Winchester City Council Position Paper on dDCO

Deadline 8 submission

TITLE: Application document reference
2.6 Converter Station and Telecommunications Buildings Parameter Plans Option B(ii)
Sheet 3 of 3

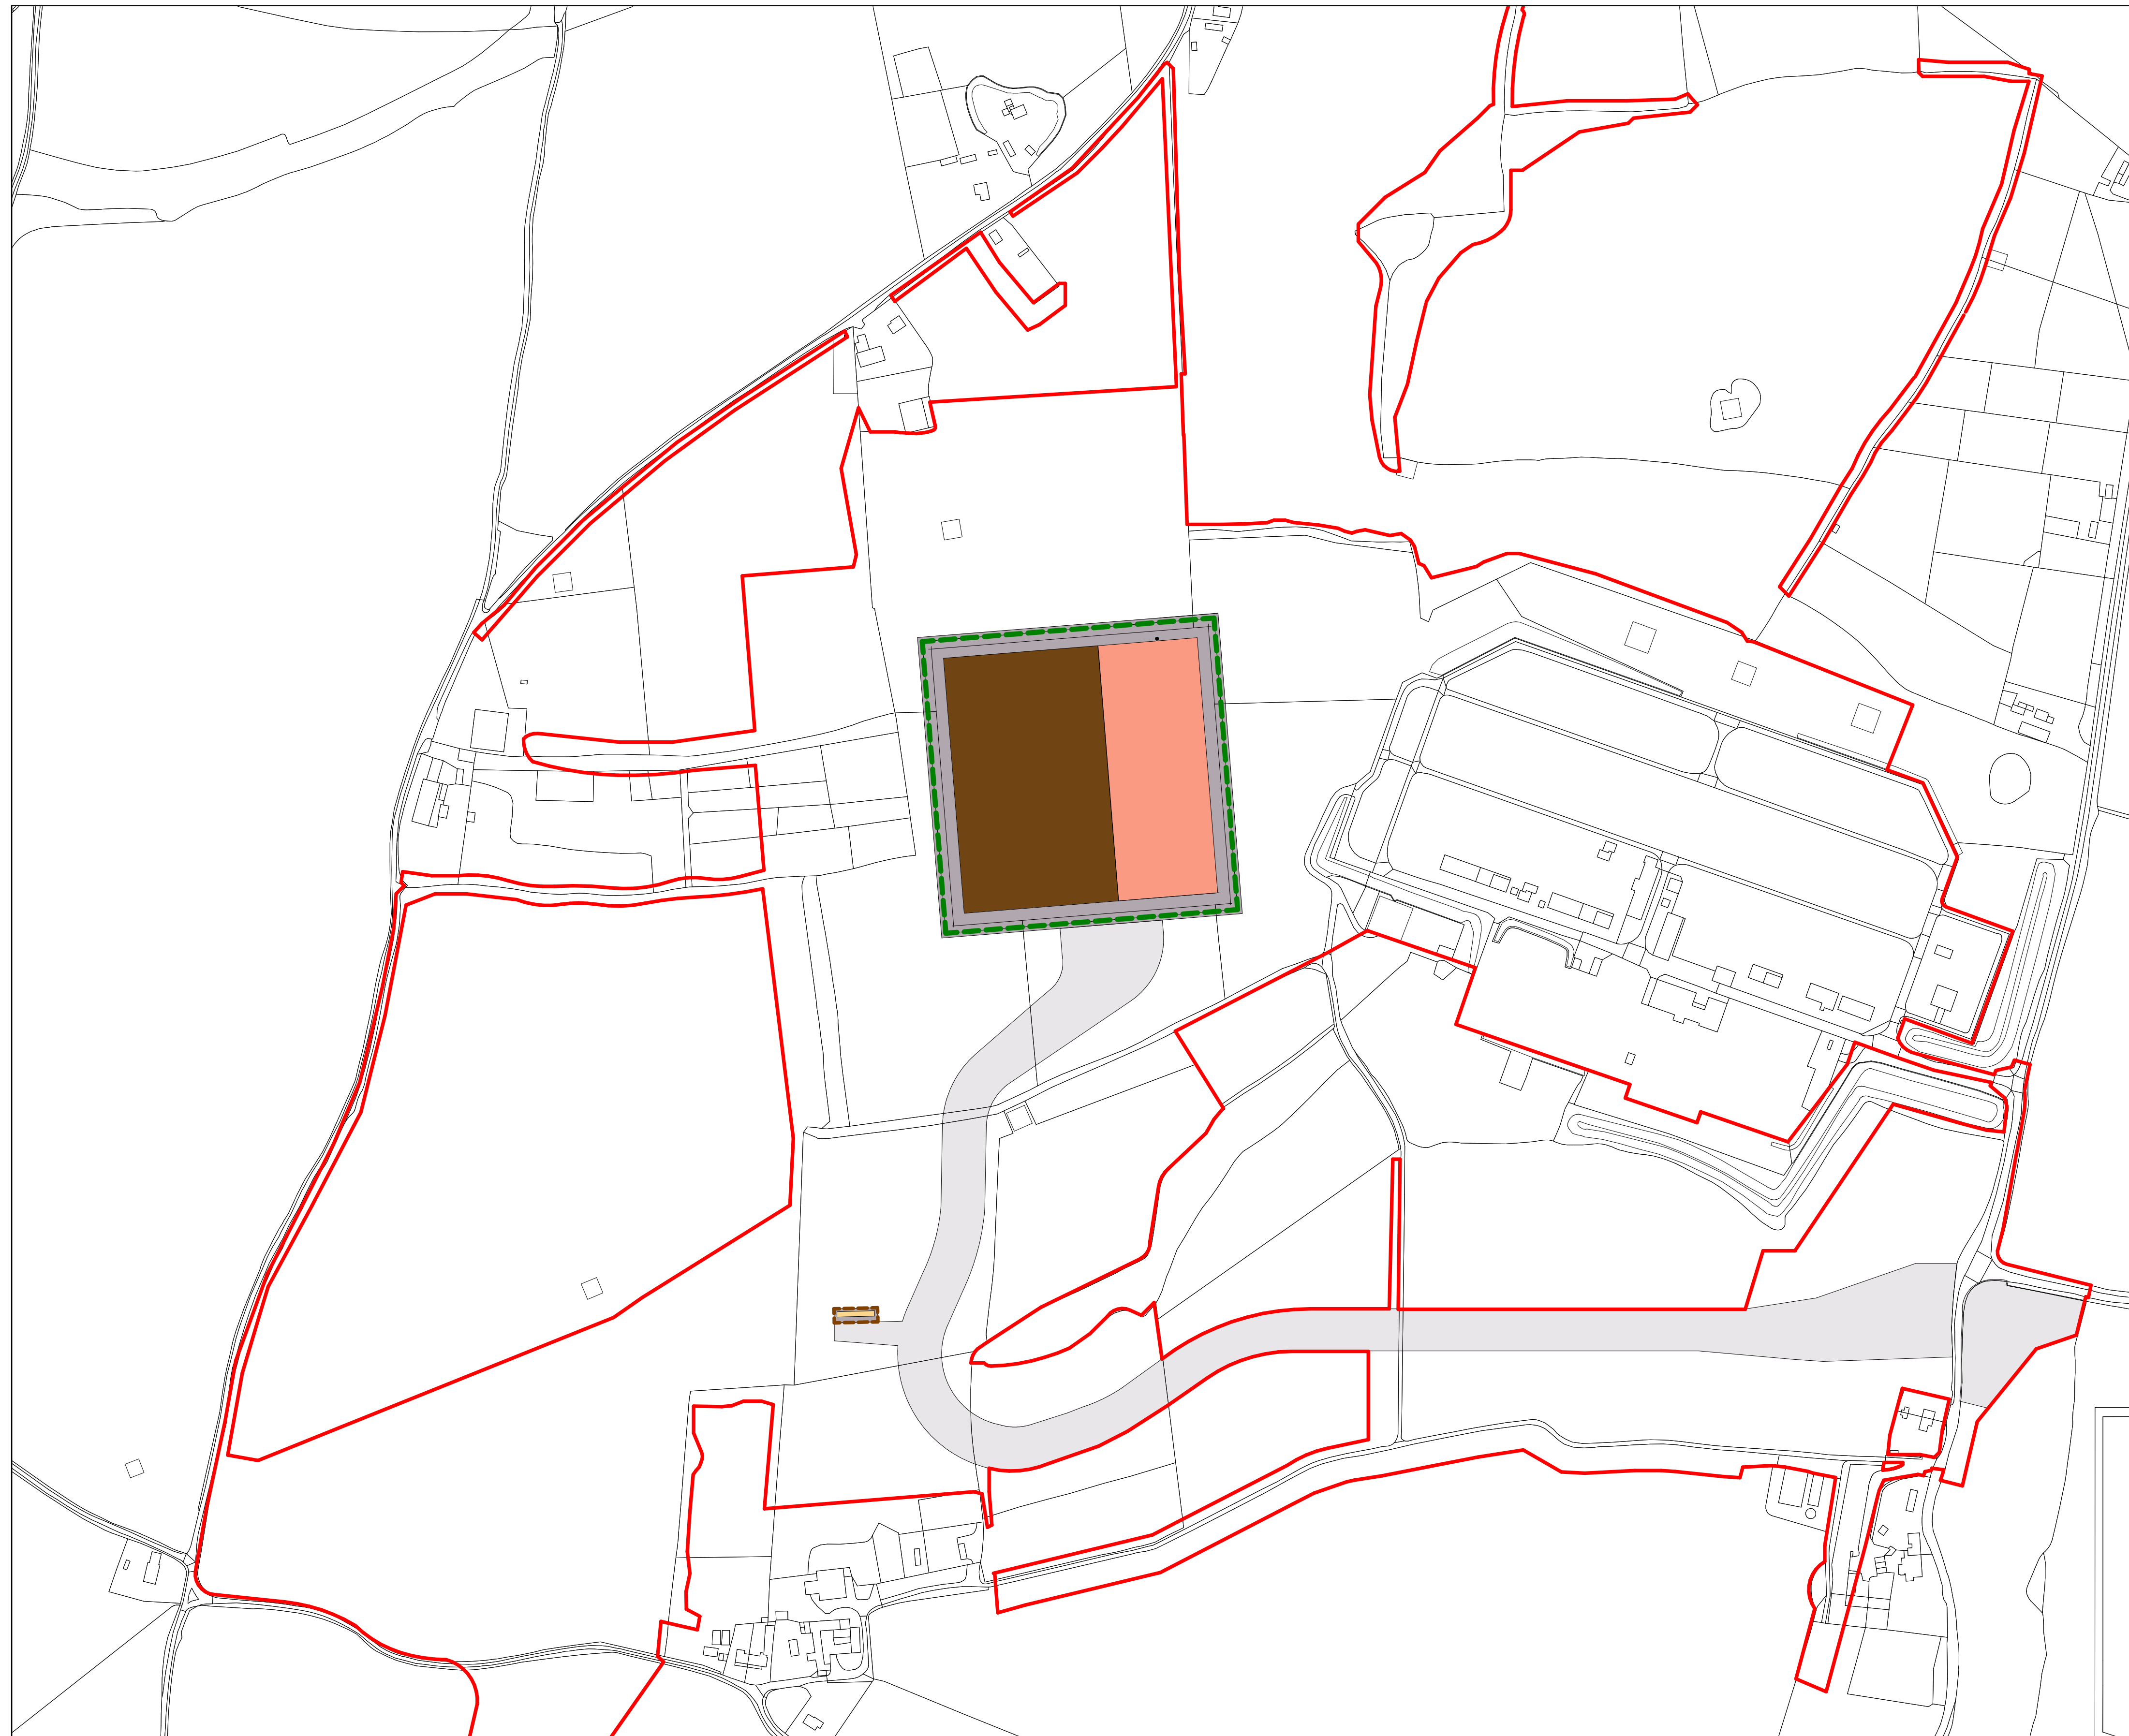
Since the submission of its Local Impact Report (REP1-183) the Council has been clear on its preference for micro siting option B(ii) and its concerns over option B(i).

The applicant has also expressed a desire to implement B(ii) over B(i) and indicated the negotiations to achieve this outcome would be completed by the end of the Examination. At this time those negotiations are still outstanding.

The Council does not wish to see the dDCO go forward with the two options but wishes the ExA to strike out option B(i). Accordingly, requirement 4 needs revising to reflect this. The following wording is offered but the Council will accept any alternative that achieves the same outcome:

For the avoidance of any doubt, the Converter Station shall only be constructed in accordance with the perimeter area that is referred to as option B(ii) on the converter station and telecommunications building parameter plan drawing number EN020022-2.6-PARA-Sheet 3 rev02 as listed in Schedule 7 to the Order.
